THE PORT OF TILBURY (EXPANSION) ORDER

Summary of Representations submitted on behalf of the Port of London Authority at the ISH on the dDCO 21 February 2018

Unique Reference Number	TR03003
Rule No.	8(1)(a), and 10(1), (2) and (4)
Document Ref.	PLA2
Author	Winckworth Sherwood LLP
Date	20 March 2018
Date of revision and version number

TILBURY 2 –SUMMARY OF THE PORT OF LONDON AUTHORITY’S SUBMISSIONS AT THE ISSUE SPECIFIC HEARING- 20 February 2018

REVISED LIMITS OF DREDGING PLAN
TILBURY 2 DOCUMENT REF: POTLL/T2/EX/45

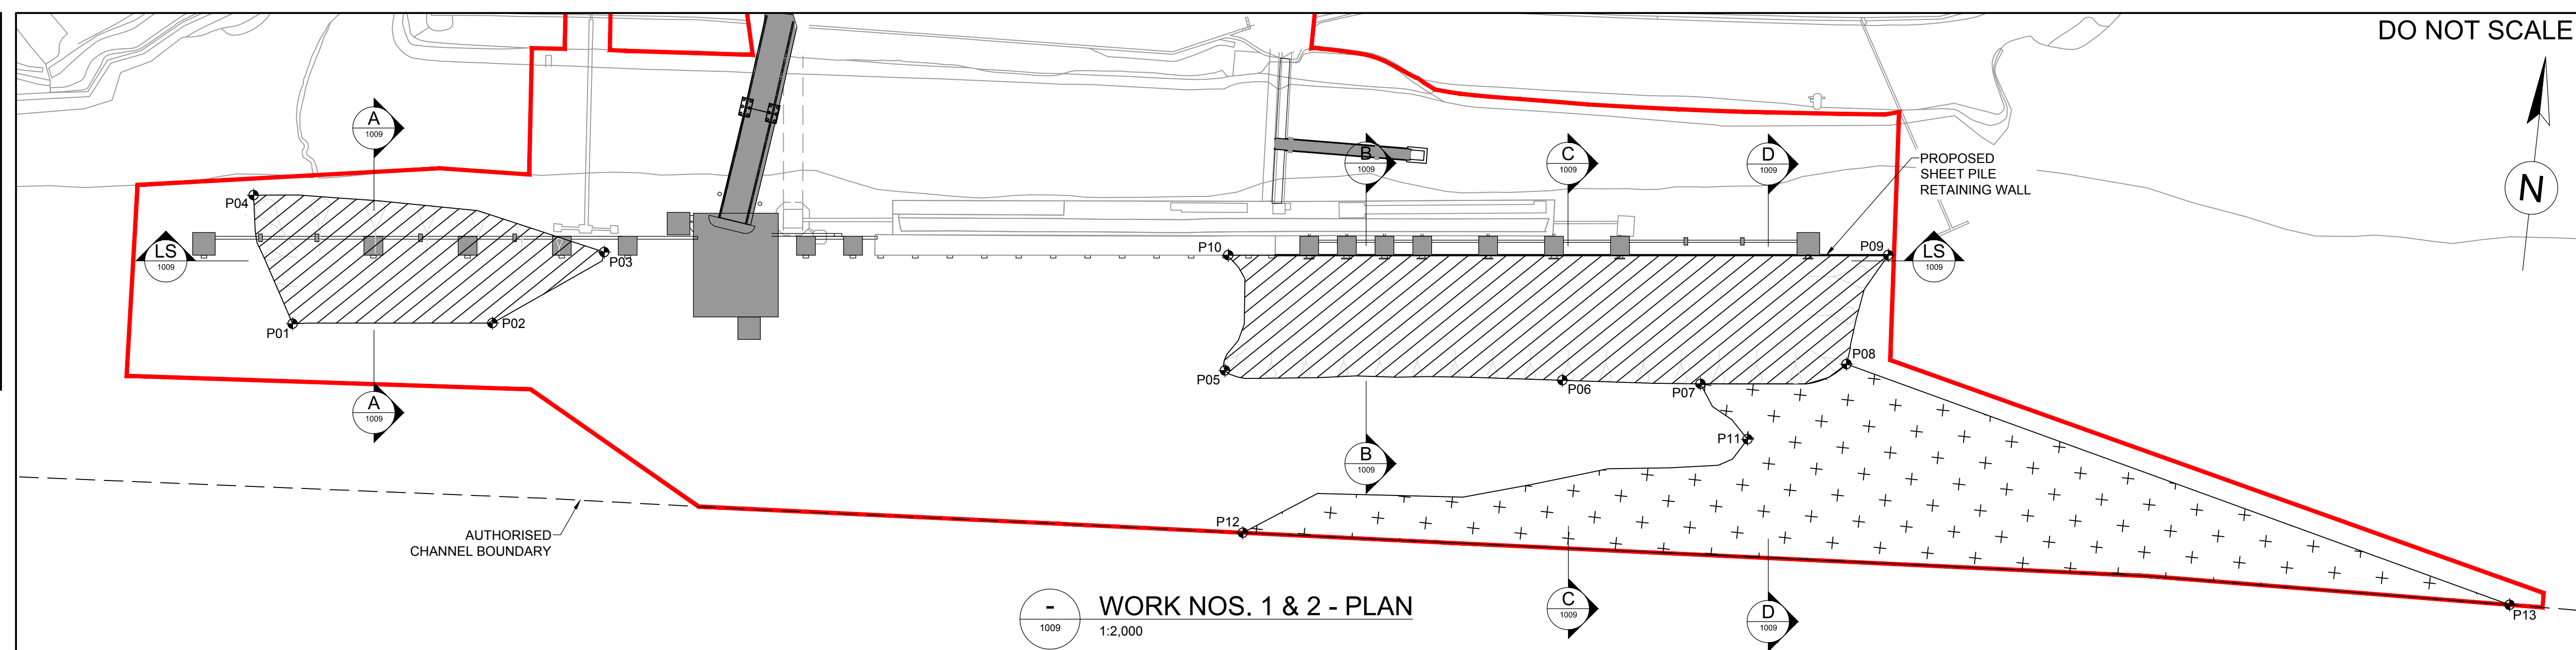
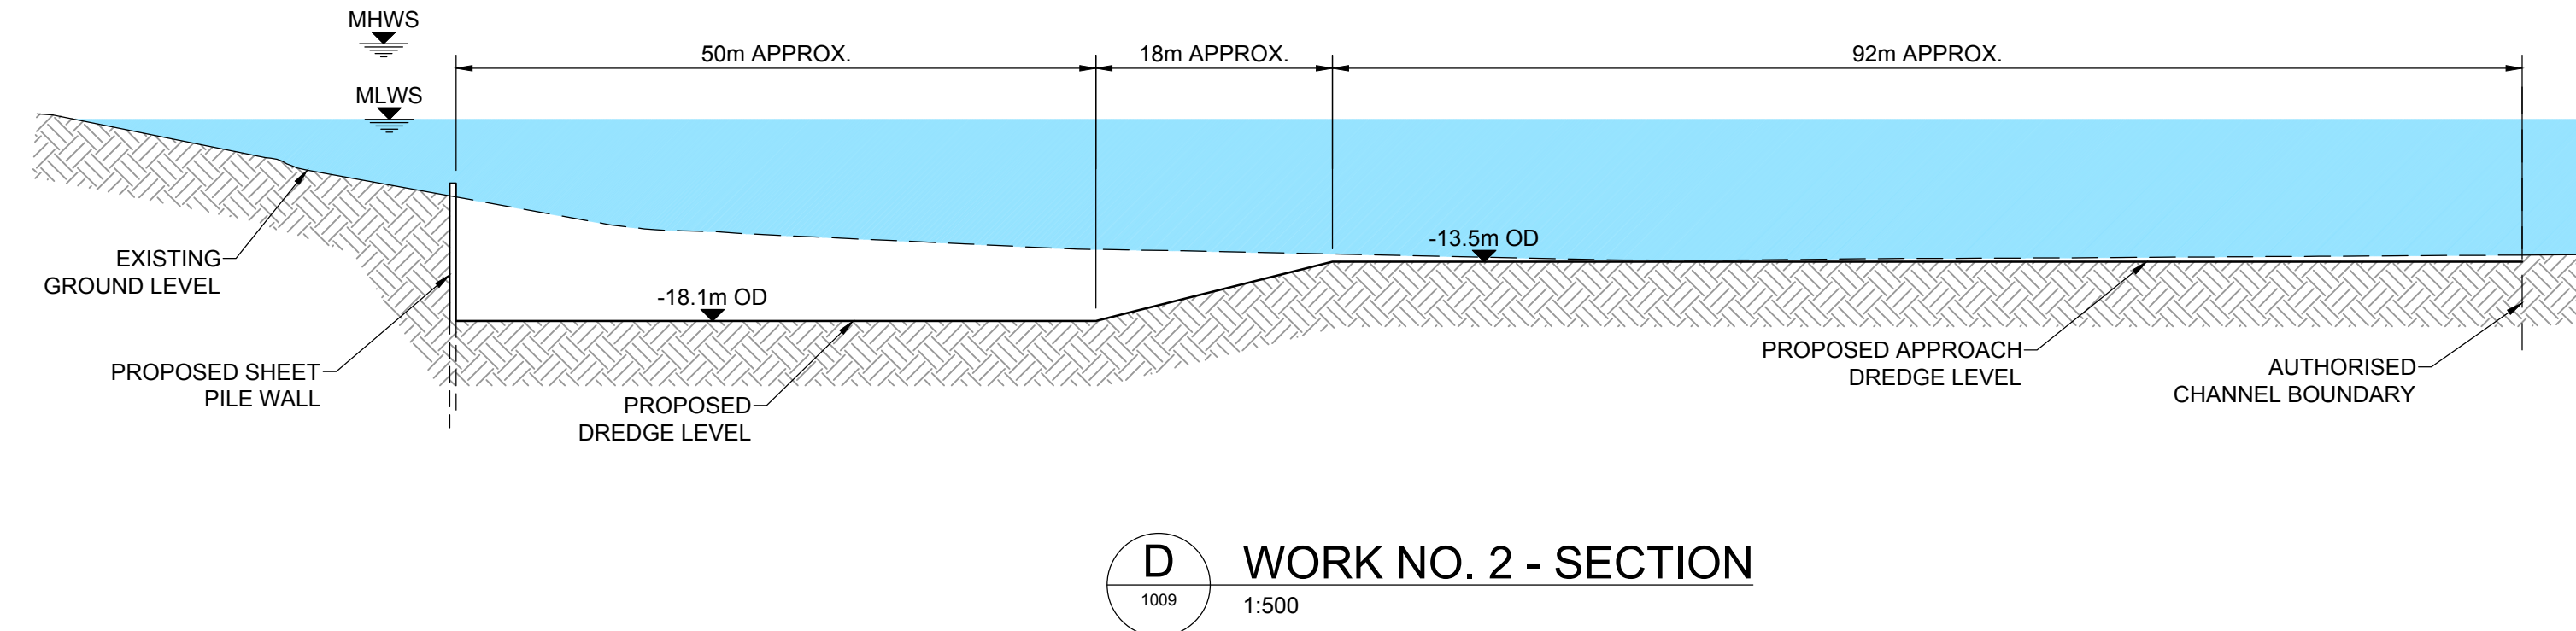
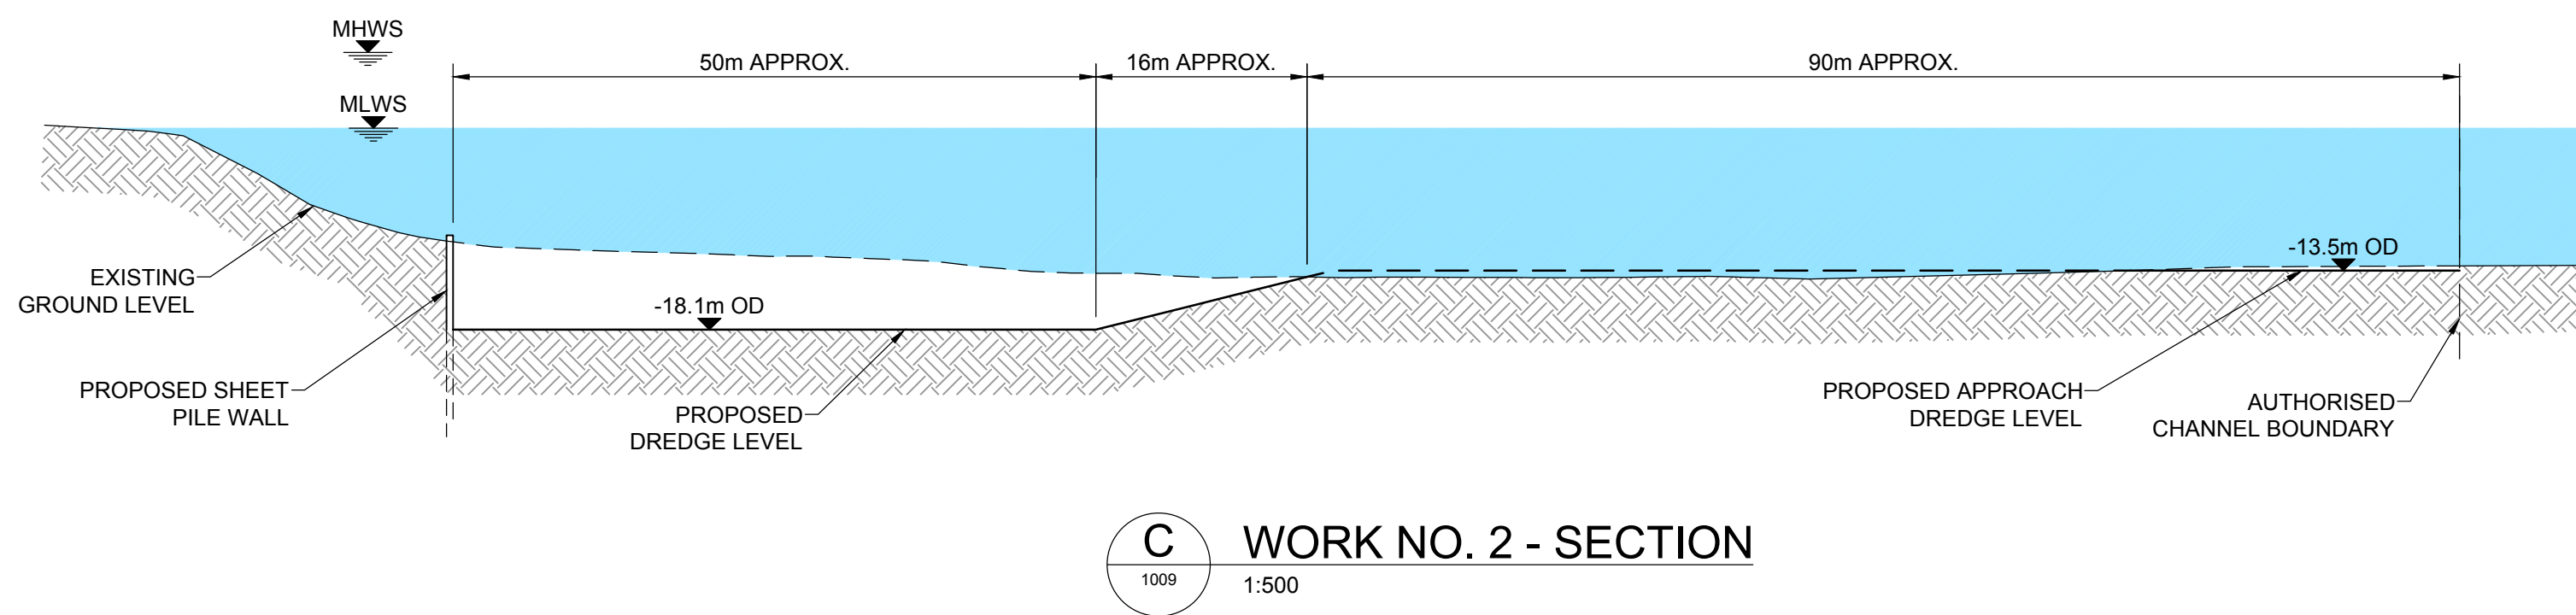
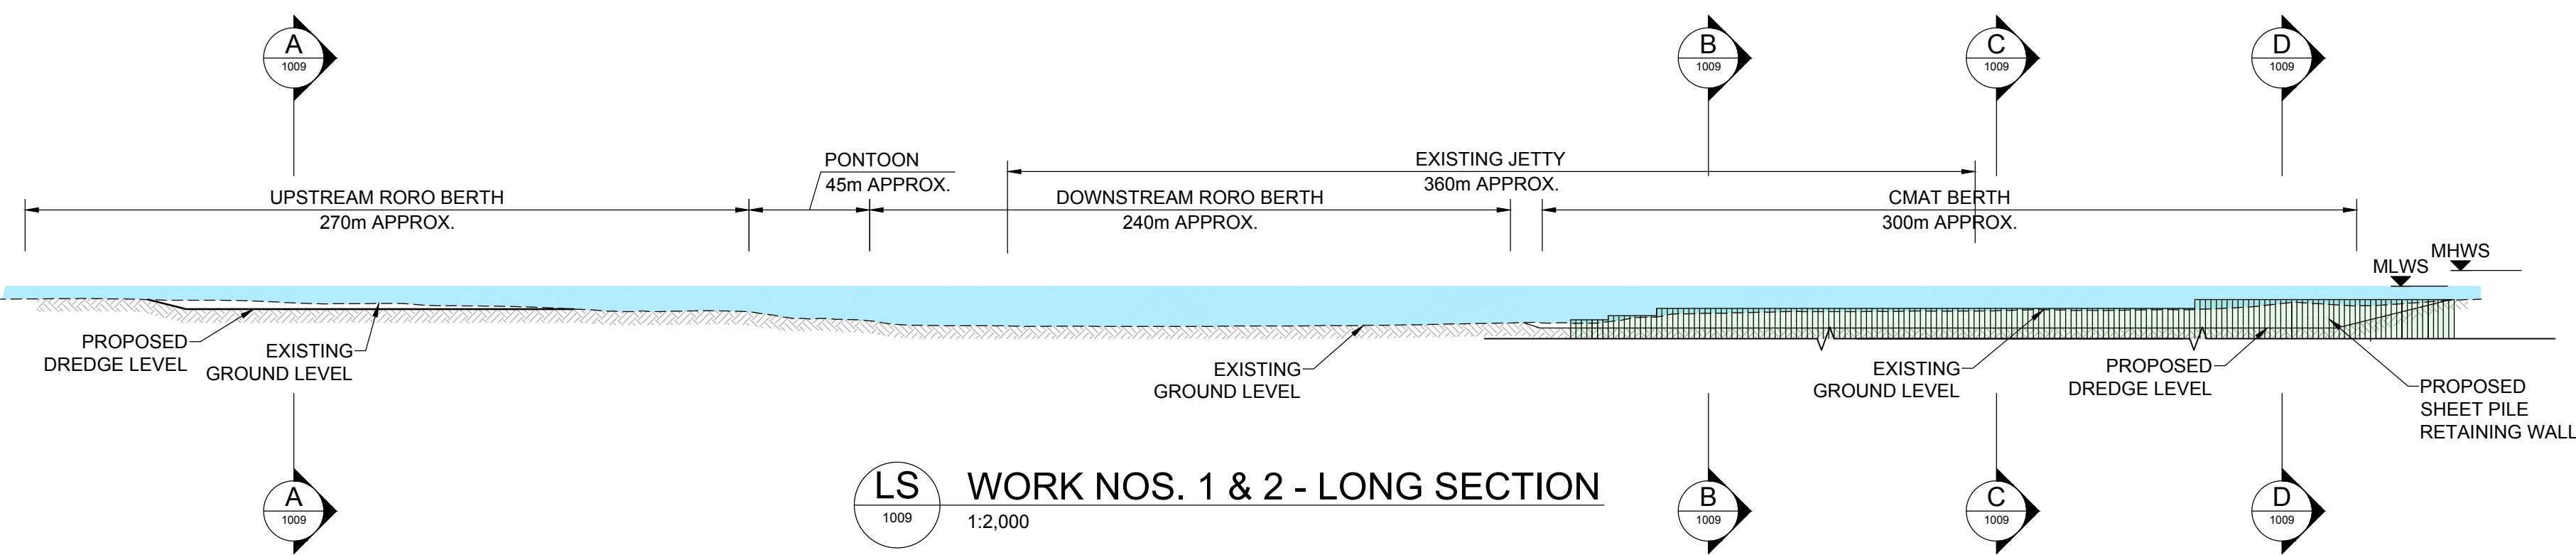
Article/Reference	Summary of provision	Issues
MAIN BODY OF ORDER		
PART 1 (PRELIMINARY)		
“Order limits” and limits of deviation		PoTLL and the PLA are in discussion as to the extent of the Order limits within the river, the limits of deviation and dredging depths. The PLA welcomes PoTLL’s commitment to provide revised plans showing the dredging depths.
